OXFORDSHIRE COUNTY COUNCIL'S RESPONSE TO CONSULTATION ON THE FOLLOWING DEVELOPMENT PROPOSAL

Application no: 22/03877/F

Proposal: Erection of three industrial buildings, replacement of former scout hut building and associated works

Location: Hatch End Old Poultry Farm, Steeple Aston Road, Middle Aston, OX25 5QL

REV.	I - 19.04.23 - Application boundary amended		
PROJECT	Hatch End Industrial Estate, Middle Aston		
TITLE	Site Plan, Proposed		
SCALE	1:750 @ A3	DATE	25.07.22
DWG. NO.	2203.PR.03	REV.	I

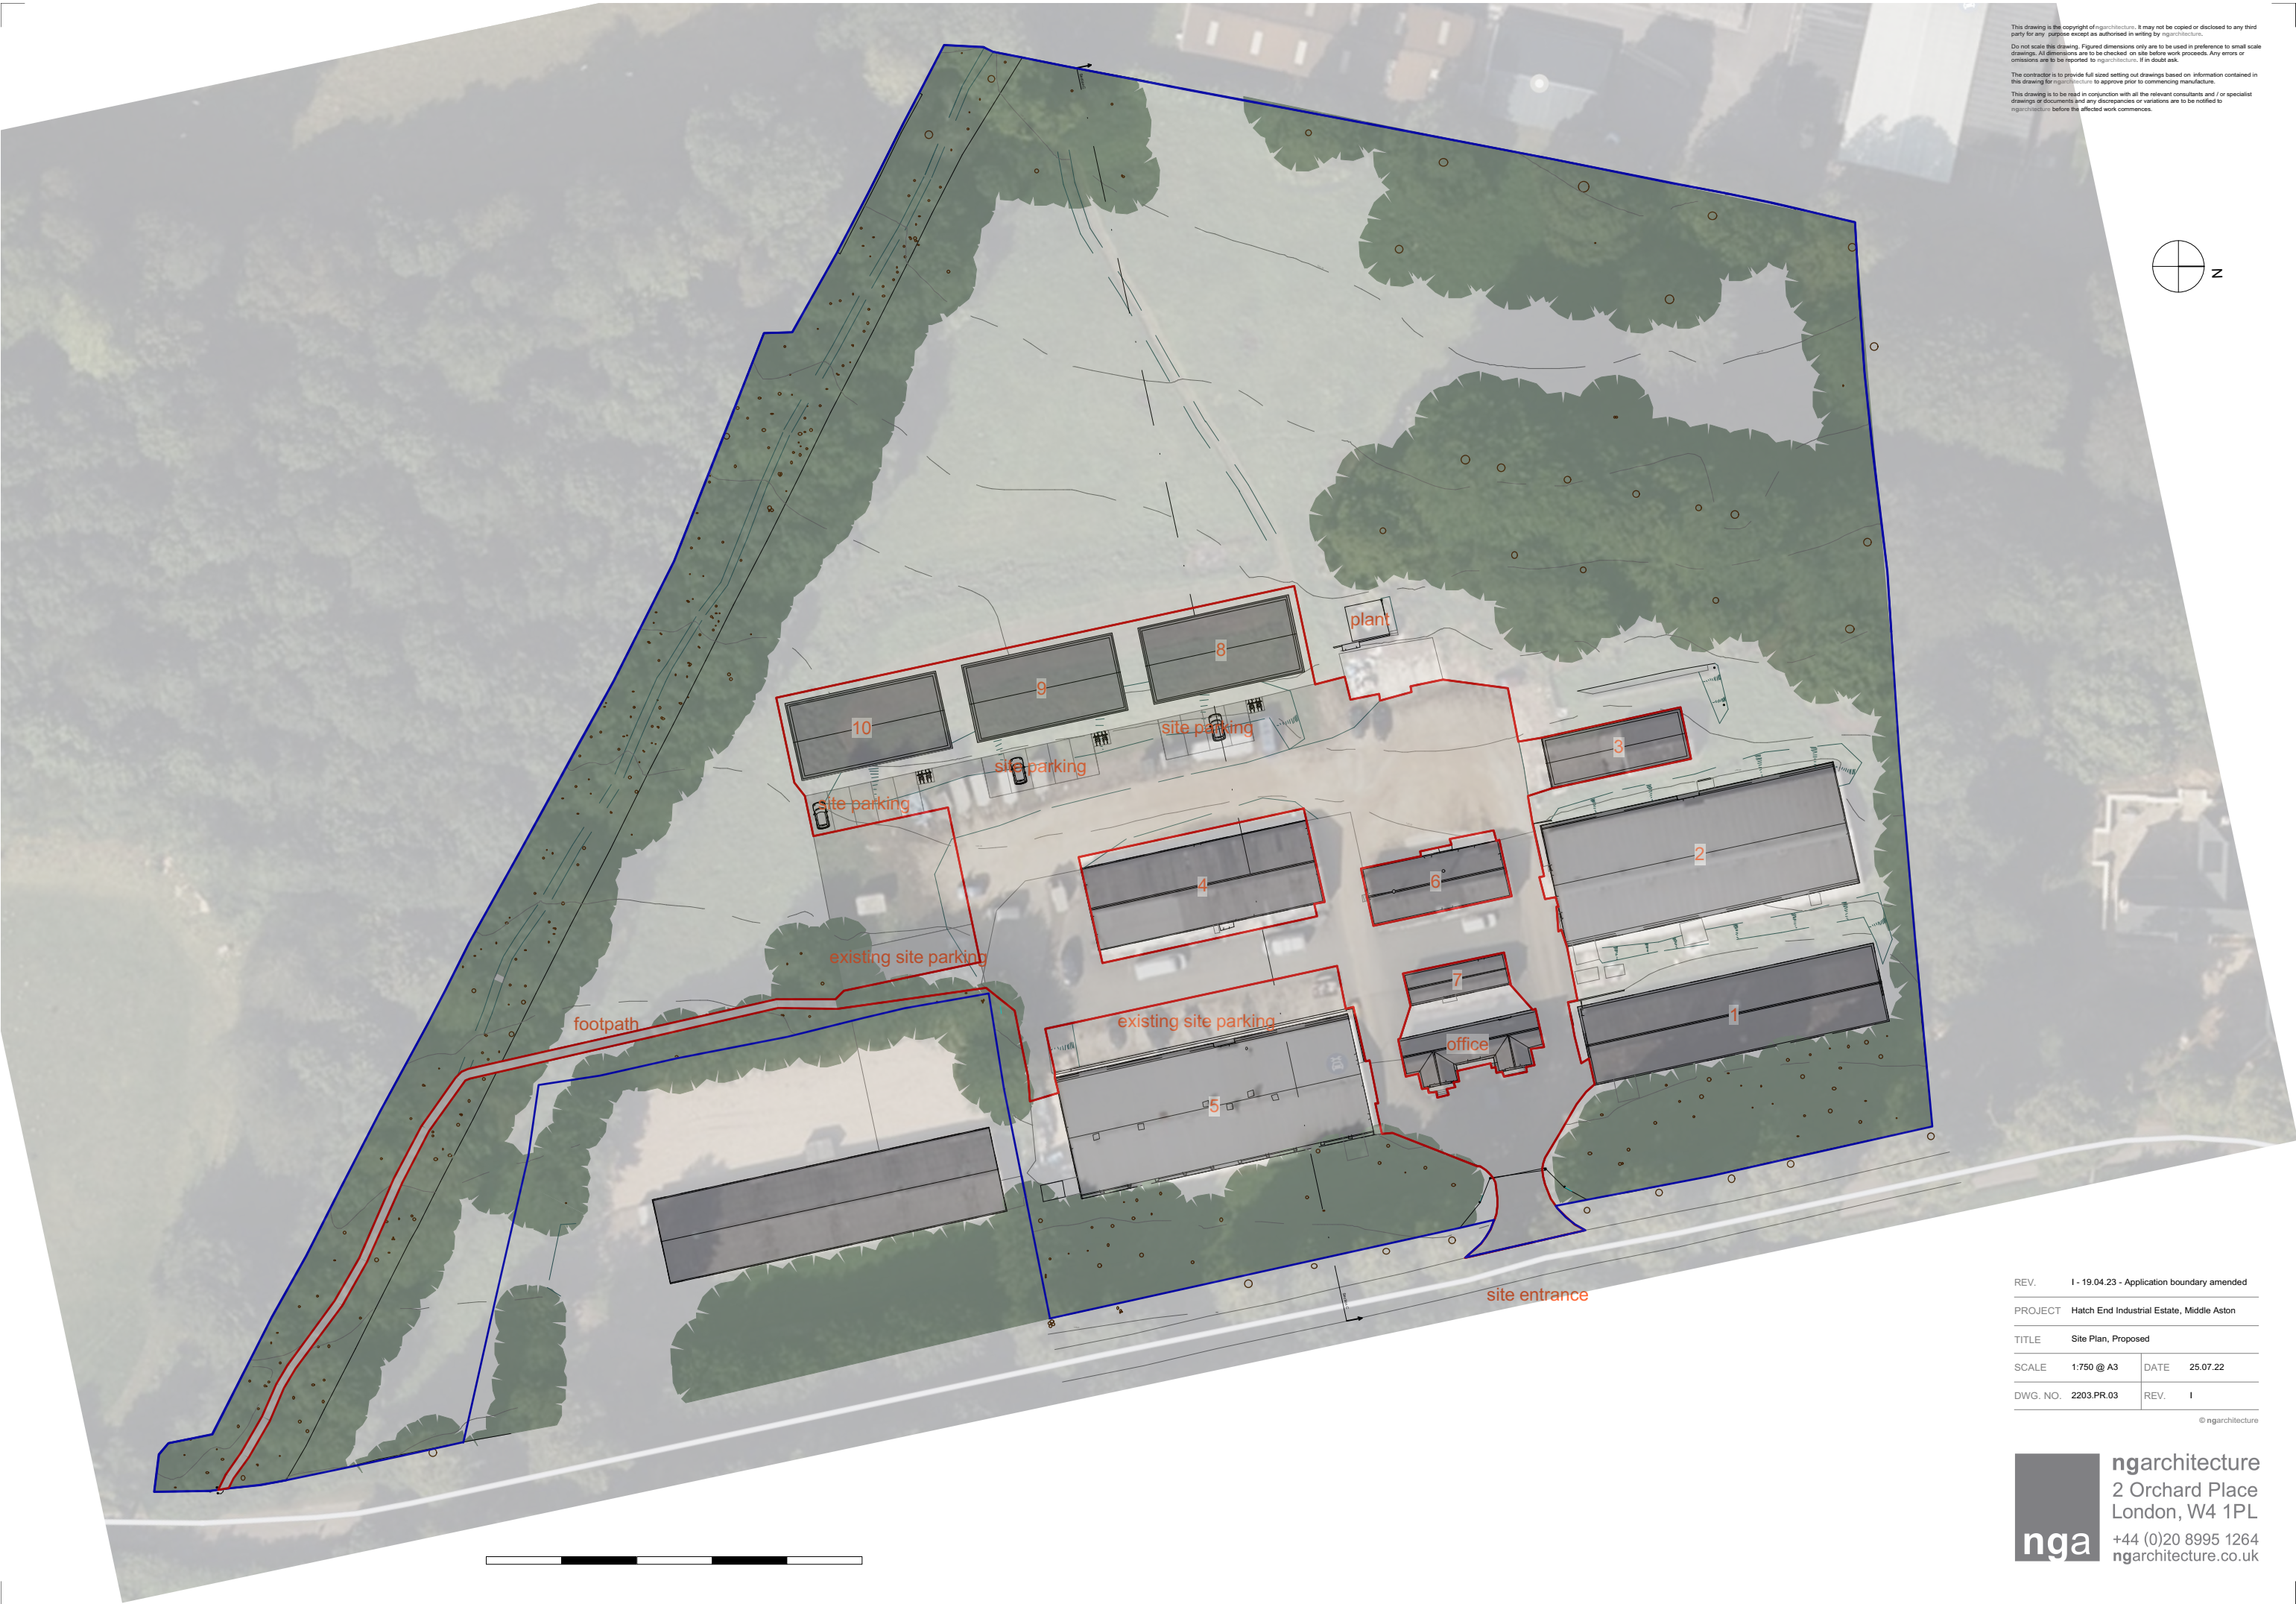
The proposed site plan drawing No.2203.PR.03 shows a footway from the site connecting with an existing footpath which borders the southern boundary of the site and connects with Fir Lane. It has been agreed by the County under planning application No.21/01123/F for this site that this would provide a suitable pedestrian route between the site and Steeple Aston to the south. The County would take this opportunity to specify that the internal pedestrian connection should be accompanied by improvement works to the surfacing of the public footpath to which it connects. This item is no longer a reason for objection.
